About the application

Application number: 2026/92154	
What is the application for?:	Removal of existing garage and erection of two storey side extension with porch
Address of the site or building:	12, Birch Grove, Batley, WF17 0RQ
Postcode:	WF17 0RQ

PROPOSED SITE PLAN

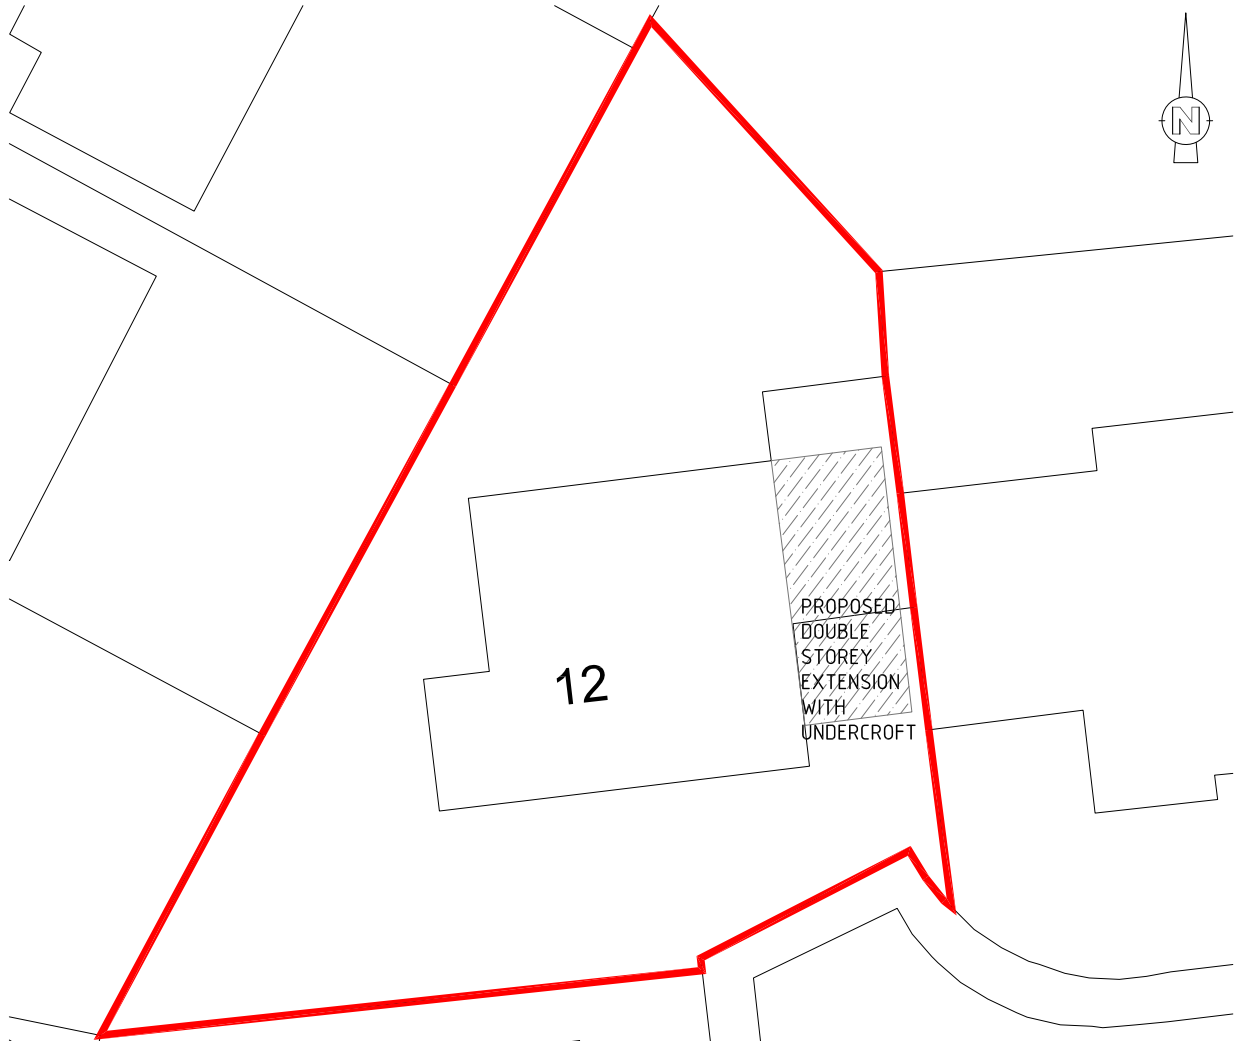
There needs to be more parking made on the premises of 12 Birch Grove for the resident's cars, in proportion with the living accommodation. A solution needs to be found before planning is granted.
